19/02261/DISC  
Swalcliffe Park Equestrian Ltd, Park Lane, Swalcliffe

Discharge of conditions 6 of 19/00171/F

Title: Landscape Strategy

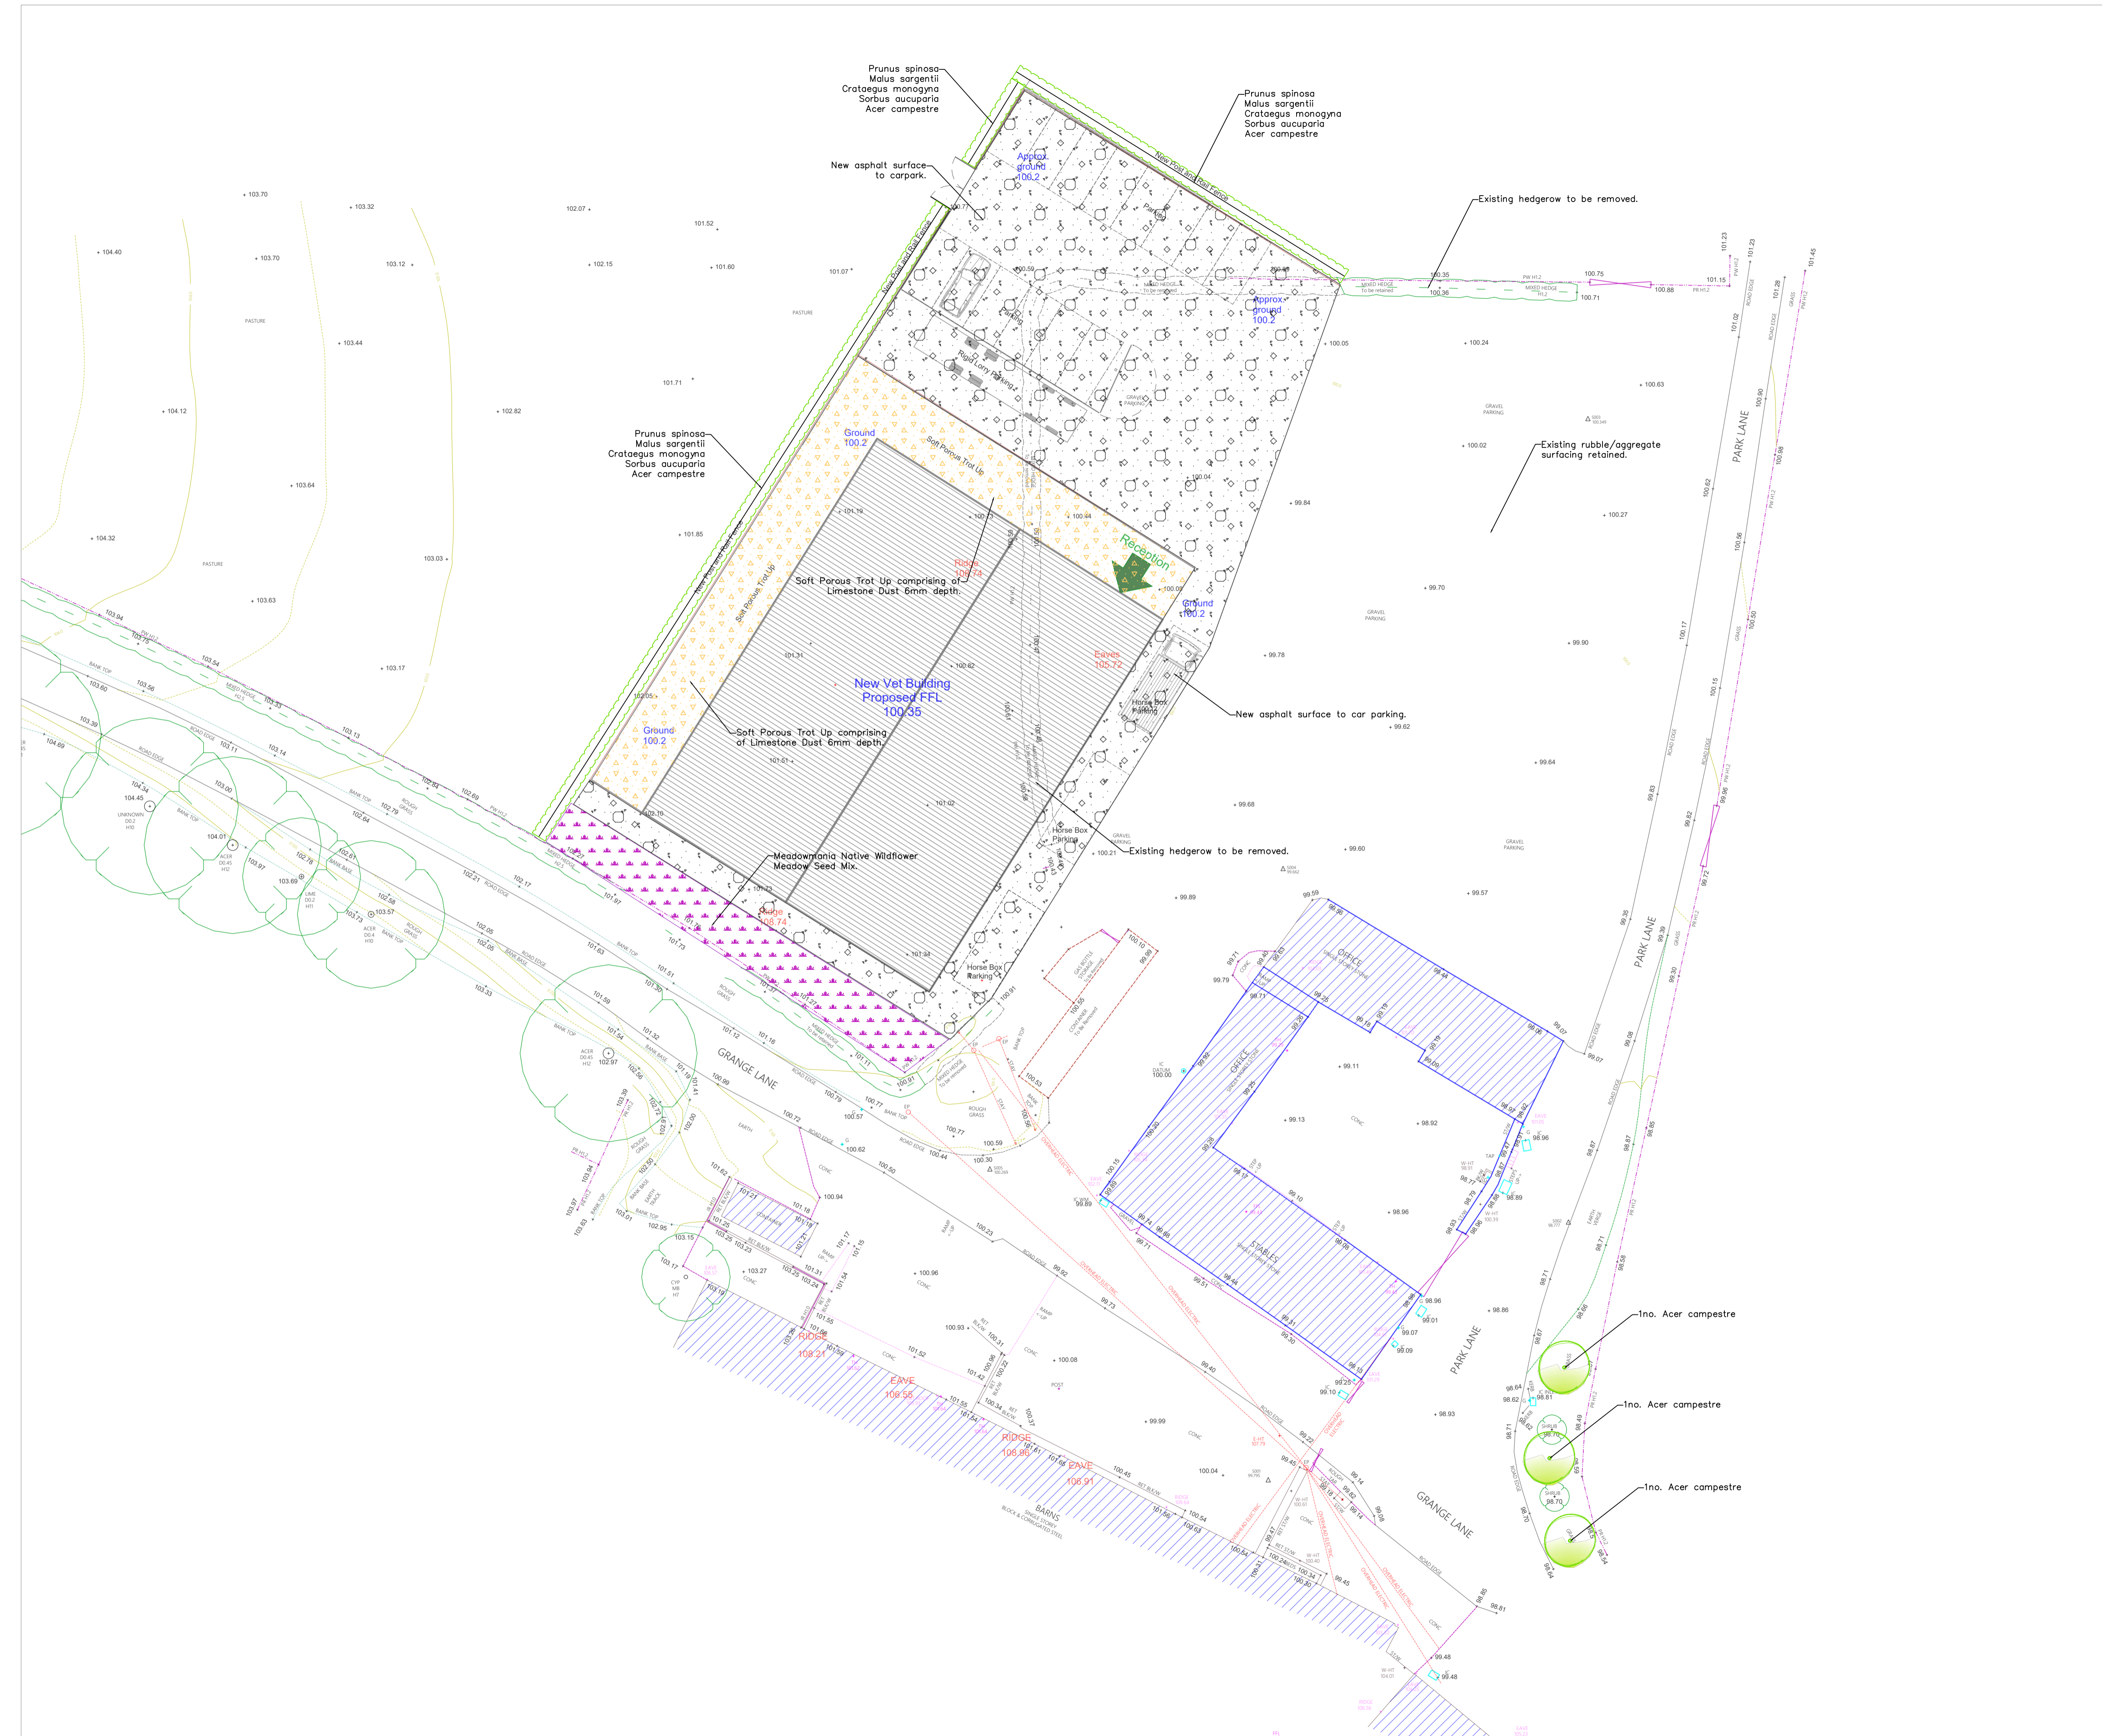
In addition the plans in the appendices show a verge of 'meadowmania' wildflower mix to be planted to the roadside of the building with some basic management information in a text box however the text of the statement only gives generic 'grassed areas' management. This should be amended so there is no confusion over how to manage the wildflower area as its value and establishment greatly depends on management. These are small points but the overall biodiversity net gain on site is likely to be quite marginal here given the small area given over to it and will depend on these details. We need to seek a clear net gain for biodiversity from all developments in line with policy, without suitable management and the additional boxes confirmed I think net gain would not be achieved.

Date: 12/09/19	
Client: Sheldon Bosley Knight	
Project: Swalcliffe Equestrian Centre	
Title: Ecological Management Plan	
Map file reference	DWG No
190912 0722 EMP V1	Fig 1

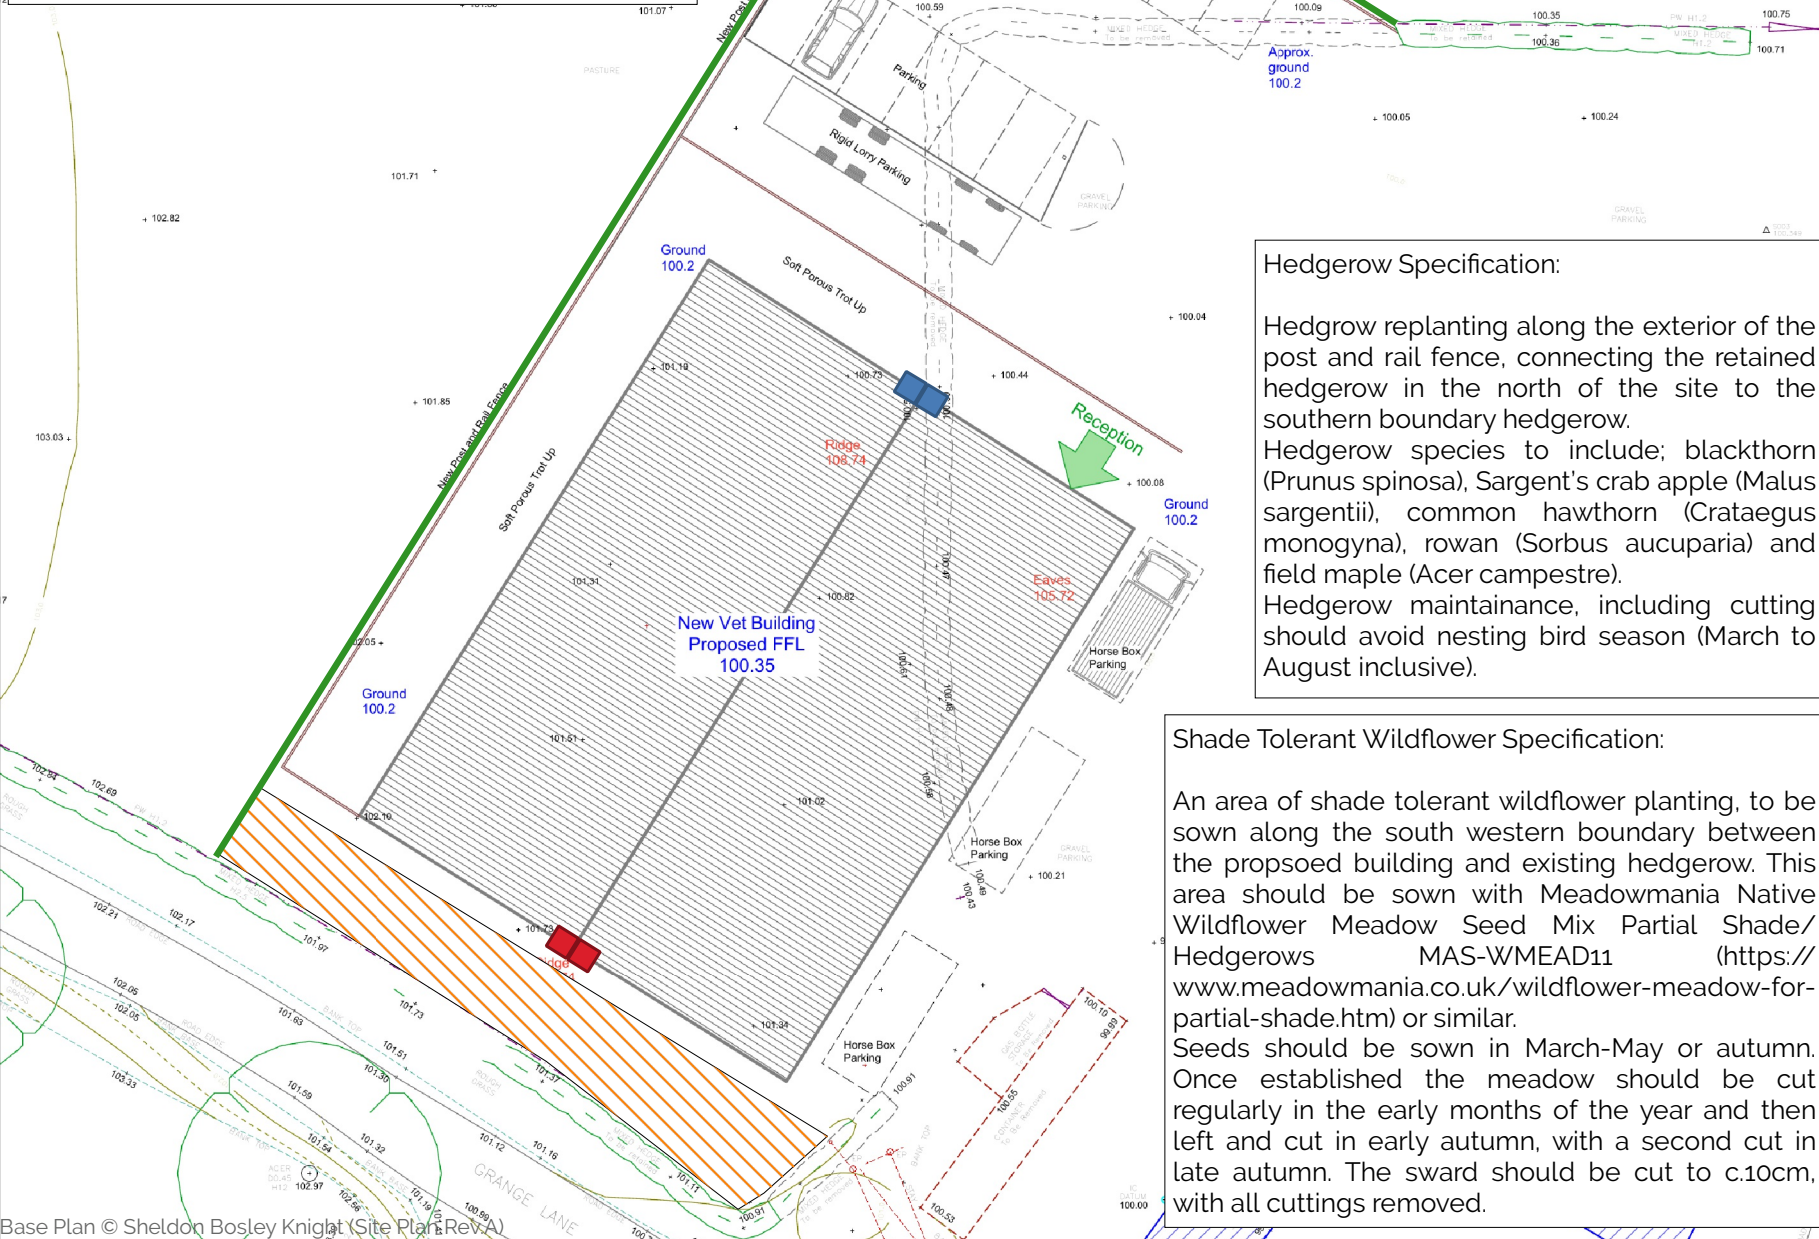
With regard to the above discharge of conditions application I have the following comments:  
The landscape statement text seems at odds in places with the final plan in its appendices which shows swift boxes on the Northern elevation of the building – these are not mentioned in the text as far as I could see. Further (and welcome) bird boxes are mentioned on an adjacent tree in the text but I could not find this one on the plan. Can they confirm that the swift boxes are still to be put in and the location of the bird boxes on a tree?
